ACP Case reference: VA29N.324276 / ACP-324276-26 - HSE NEHS submission

RE: An Coimisiún Pleanála - Case reference: VA29N.324276 / ACP-324276-26 SID Proposed development of a 110kV/38kV MV electrical distribution substation and associated works in Belmayne, Clonsaugh, Dublin 17.

National Environmental Health Service Submission Report

Planning Case Reference No.: VA29N.324276 / ACP-324276-26

PE492-D327-006-007

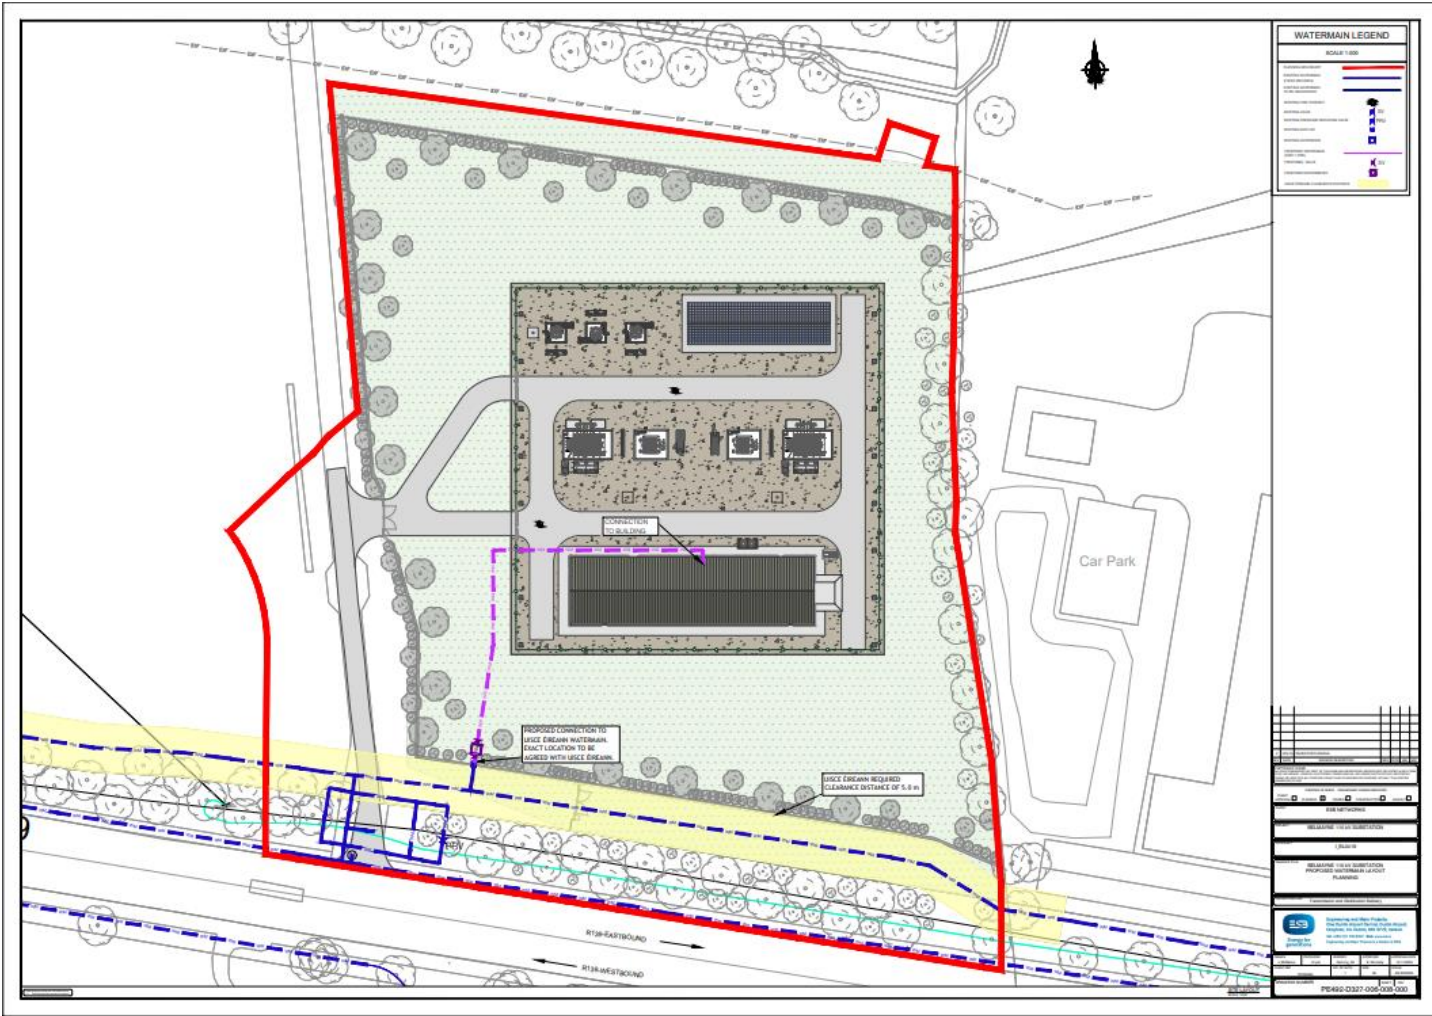
NEHS has considered section 4.2.2 of PER, Appendix B, C and Drawings PE492-D327-006-007-001 and PE492-D327-006-008, which sets out to assess the potential impacts of the development on the water environment (Surface and groundwater).
